Recommendation Report for Planning Permission for Works or Extension to a Dwelling

REF NO: WA/26/22/HH

LOCATION: Kelsey
Eastergate Lane
Walberton
BN18 0BA

PROPOSAL: Installation of a front entrance porch and covered way, single storey rear extension, two storey pitch roof side extension, conversion of roofspace to habitable use with gable end roof, detached carport and a detached summer house to rear.

Title
Elevations as Proposed

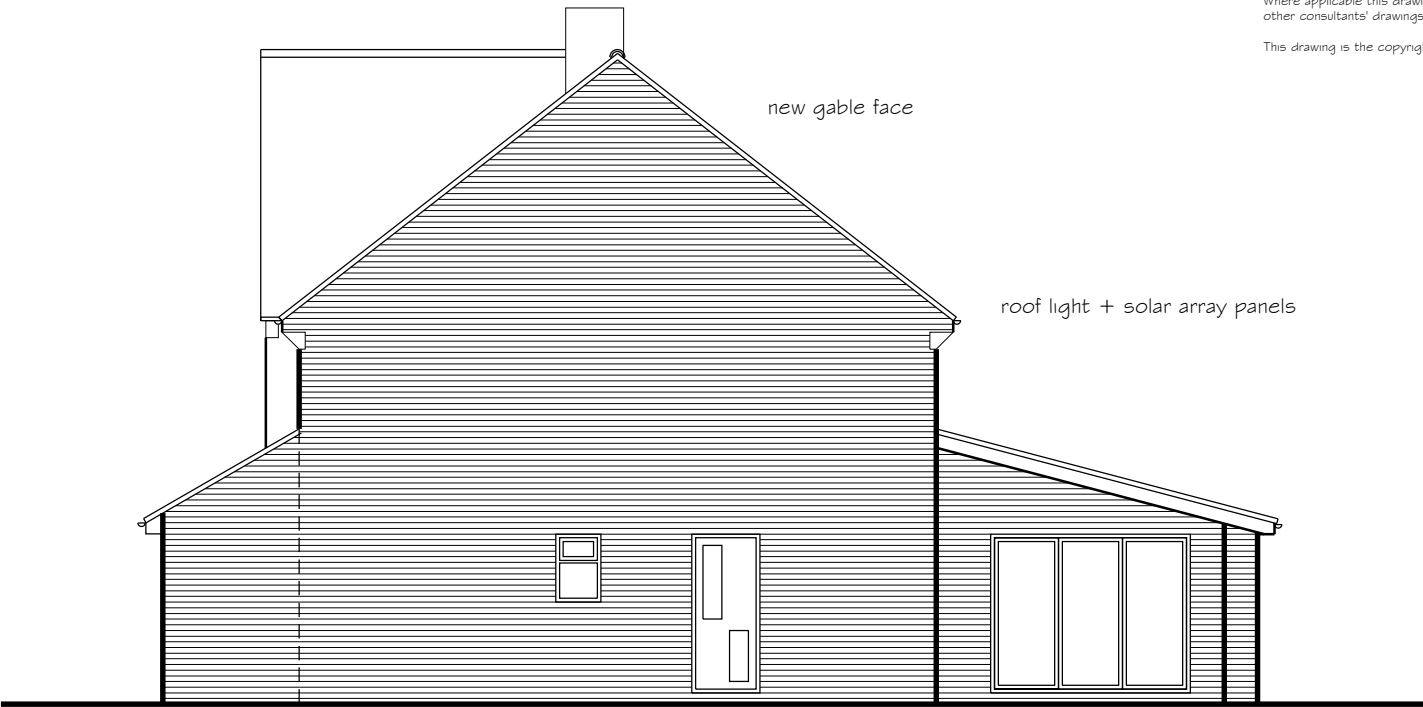
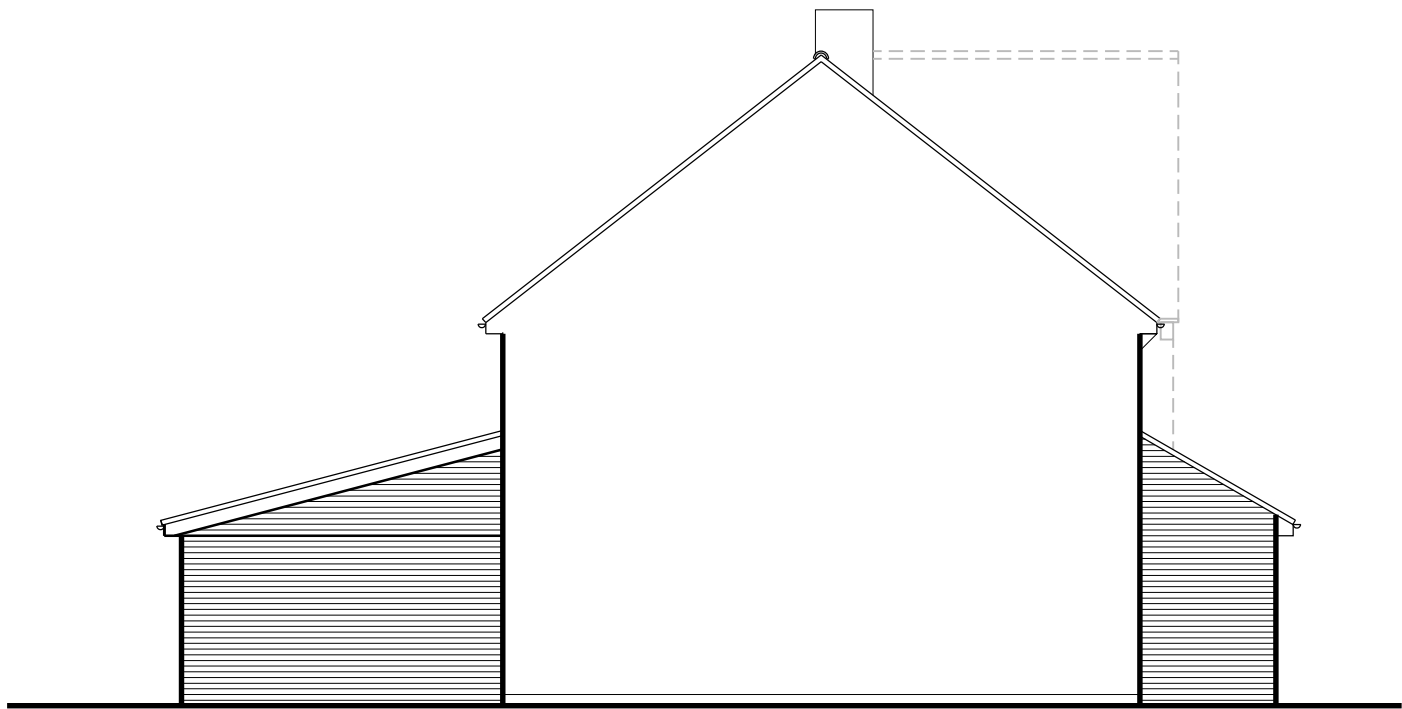
It is proposed to construct a two-storey side extension, 3.3m in width, a single storey mono-pitched front extension, 1.8m in depth, and a single storey rear extension and covered area, 4.2m deep running across the rear of the existing and proposed building. The rear extension and covered area will have a mono-pitched roof. A pitched roof carport and ancillary building are also proposed. The site sits on the boundary of the built-up area.

Due to its siting, there will be views of the proposed two storey and single storey extensions available from the public realm. The two-storey extension has been designed to include a ridge and eaves line to match the existing building. The single storey front extension has an appropriately pitched roof and although built forward of the primary elevation, has a scale far smaller than the host dwelling. All extensions are to be built from materials which match those already found on the host dwelling. Overall, the extensions are afforded good visual integration with the host dwelling and are built to a scale which is respectful of the larger plot on which the property sits. By these reasons there is no significant harm to

the character of the host dwelling, or its locality as a result of the proposed two storey side extension.

Title
Garden Room as Proposed

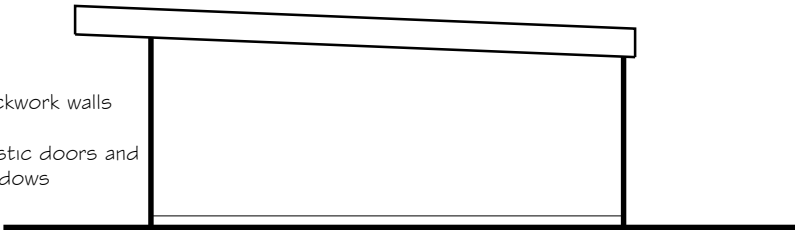
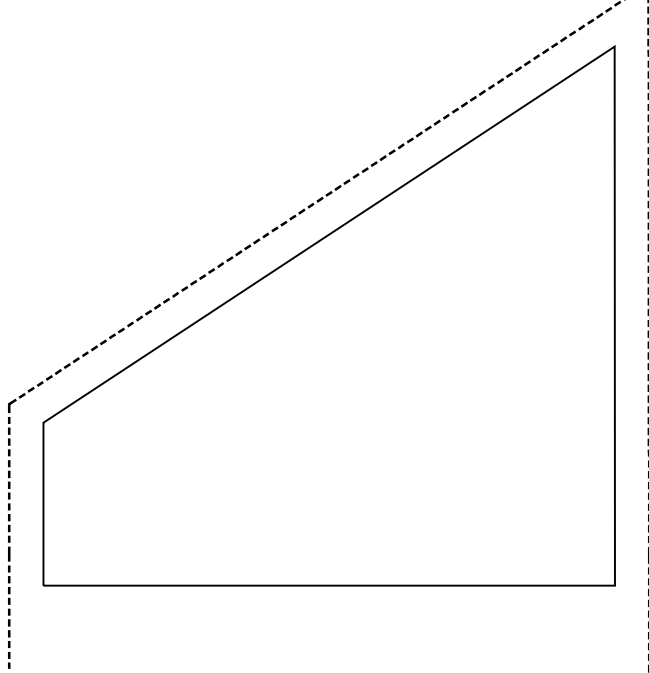
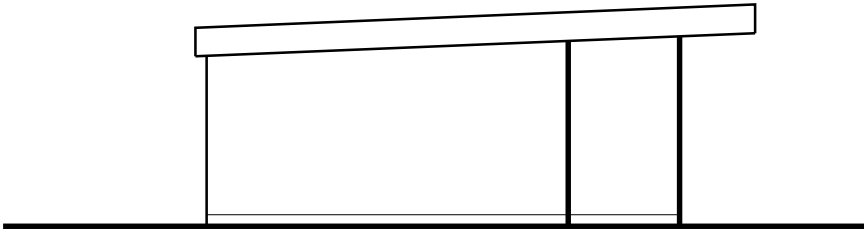
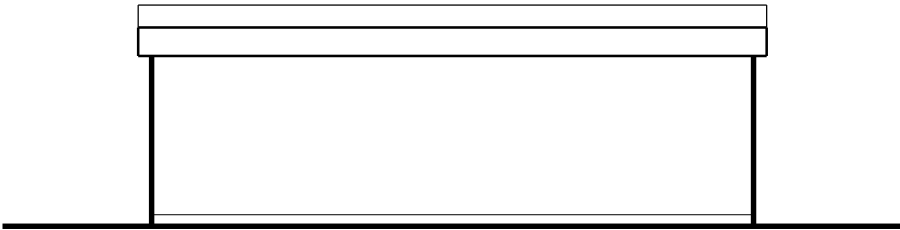
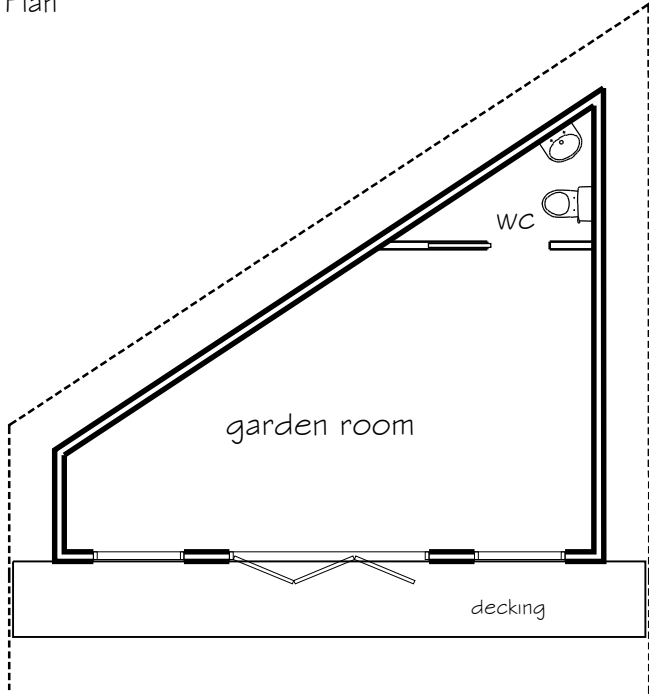
The proposed garden outbuilding has been designed to fit to the angled shape of the boundaries. It will have a flat roof with a maximum height of 2.9m and be brick built. It will replace an existing shed. By reason that it will be located to the rear of the host dwelling and as it is to be built to an appropriate scale it is considered to comply with policy, that it is subservient to the host dwelling and the wider area.

Car Port as Proposed

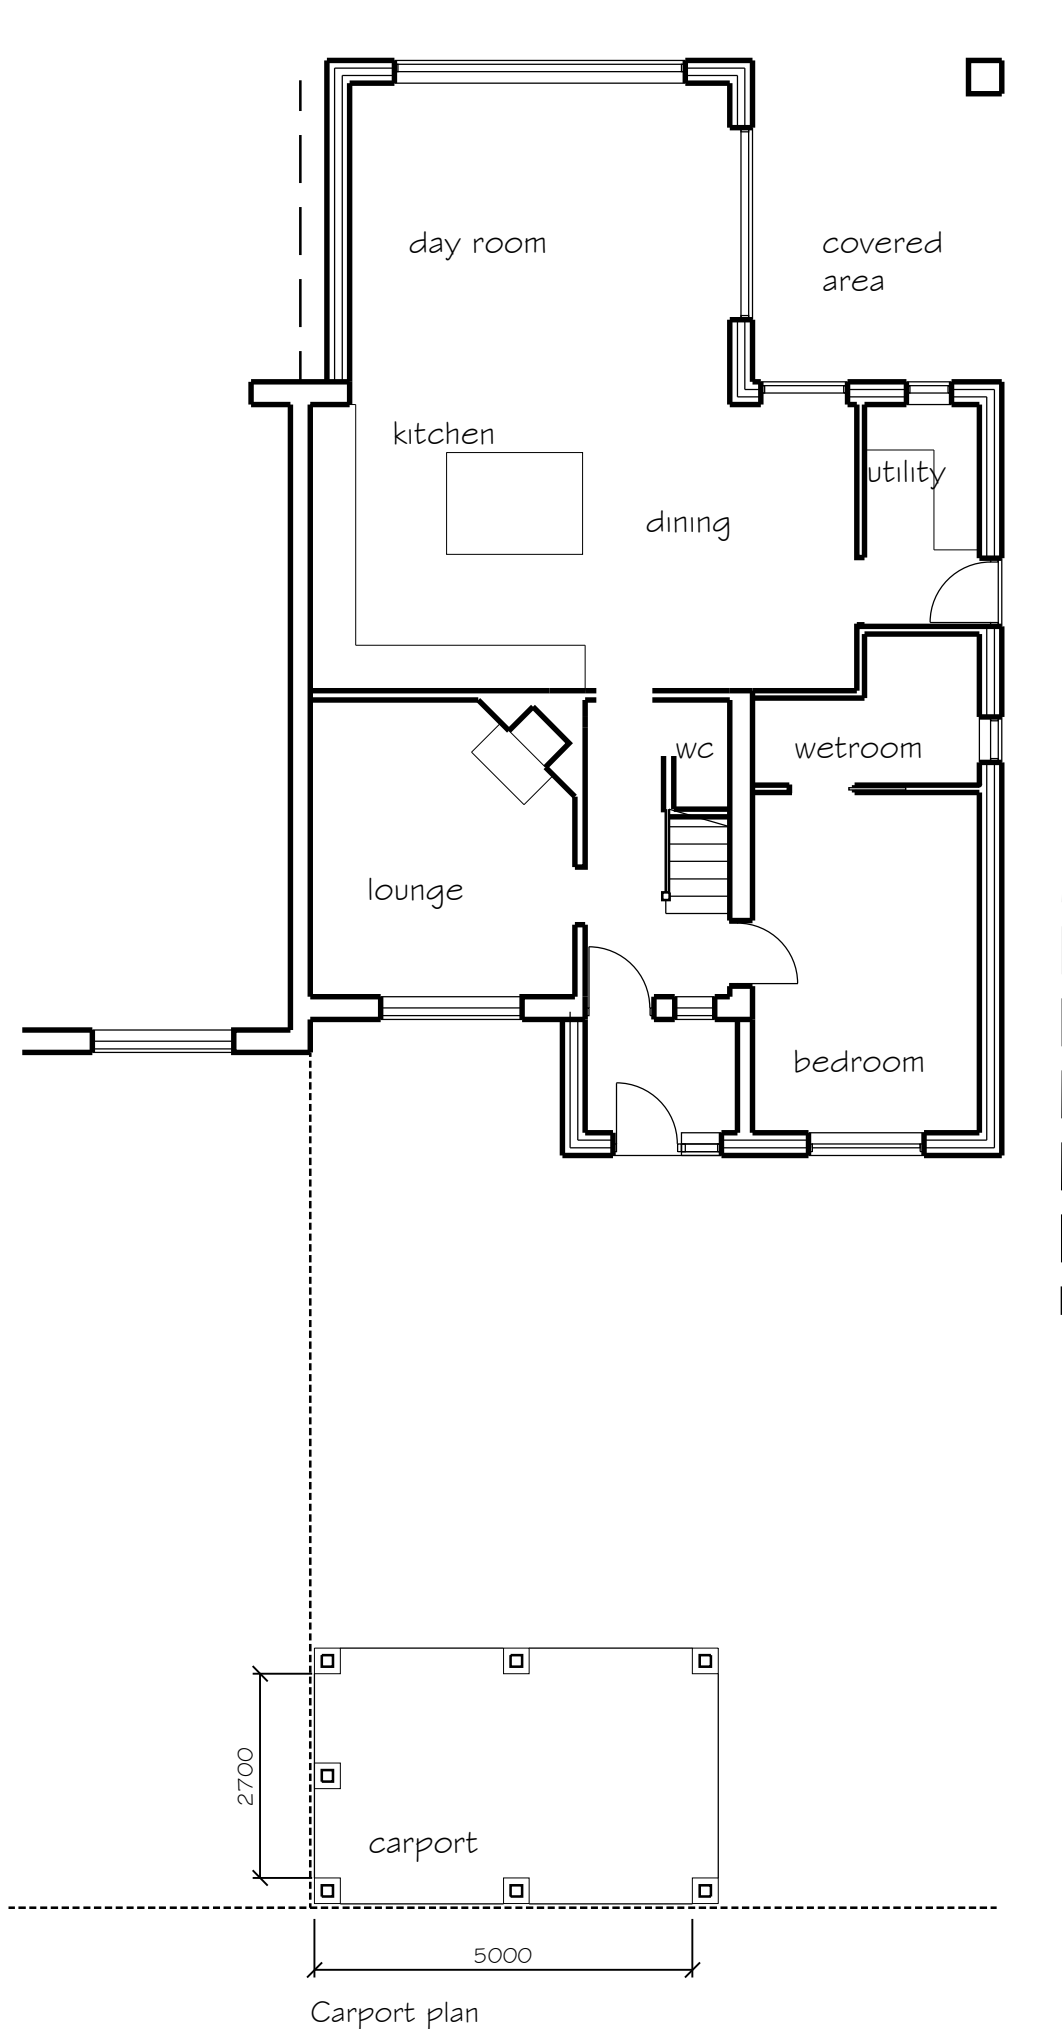
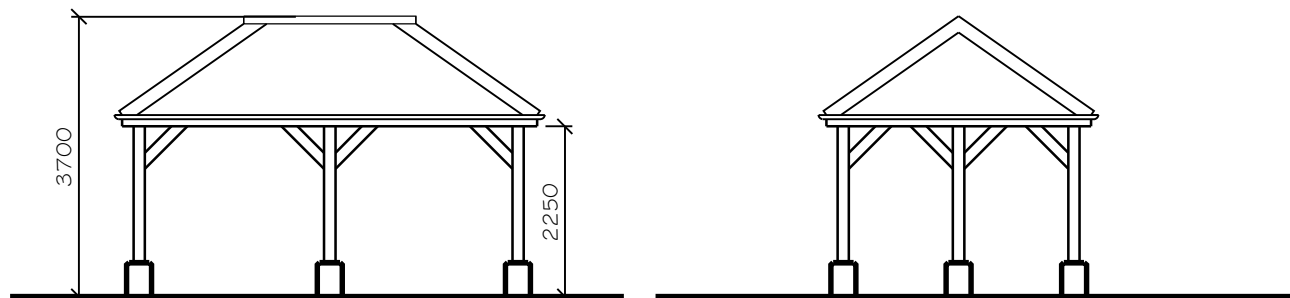
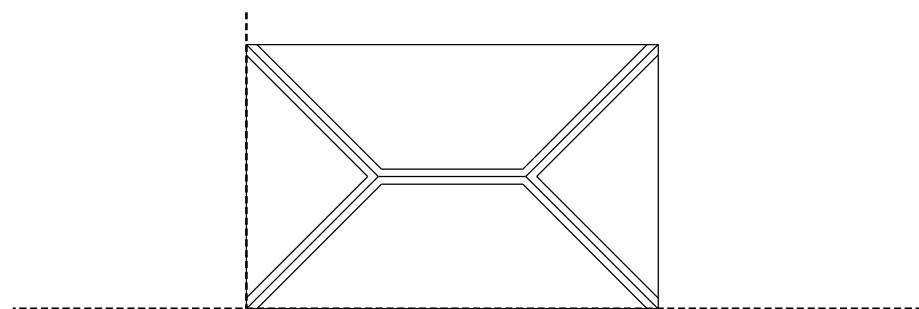
The proposed carport is sited to the front of the dwelling (south) and creates parking for two vehicles. Buildings sited to the frontages of the properties, as proposed in this case, is not in-keeping with the area. The carport is to be built to a height of 3.7m with a ridge which will run parallel to the road.

It is noted that the 3D plans and elevation do not match. The proposed built form is not considered an appropriate form of development within 100mm proximity of both the north and east boundaries and it will negatively impact the spatial character of the area. It is noted that there is tree coverage to the front of the site. This tree coverage is seen to be within the applicant's control. There are two trees sited centrally within the grass verge (6m in width) and 1 Oak tree to the neighbour's boundary. The trees sit within a semi rural location, where their character and environmental benefits provide amenity value typical of this location. The proposed carport, being located up against the boundary will cause pressure to the trees vitality as it will be built within their root protection zone which may lead to their removal/decease in the future. In addition during autumn/winter months the trees are devoid of leaf making the site clear. As such the carport would have both an unacceptable negative impact to the street scene by reason that it would be out of character and have a negative impact on the health of the tree in conflict with policies D DM1, D DM4 and ENV DM4 of the Arun Local Plan.

The proposed carport conflicts with policies D DM1(1), D DM4(e) and ENV DM4 and Part M of the Arun Design Guide, and HP13 of the Walberton Neighbourhood Plan in that it is not in keeping with the character and spatial pattern of the area and that it will negatively impact trees with a high amenity value within a countryside location.

- 1 The proposed carport, by reason of its scale and positioning abutting the front boundary will appear out of keeping and significantly harm the character and appearance of the area. It will also place undue pressure on the tree which could provide the carport with some mitigating screening. The proposal is therefore in conflict with policies D DM1, D DM4 and ENV DM4 of the Arun Local Plan, HP13 of the Walberton Neighbourhood Plan and the Arun Design Guide.
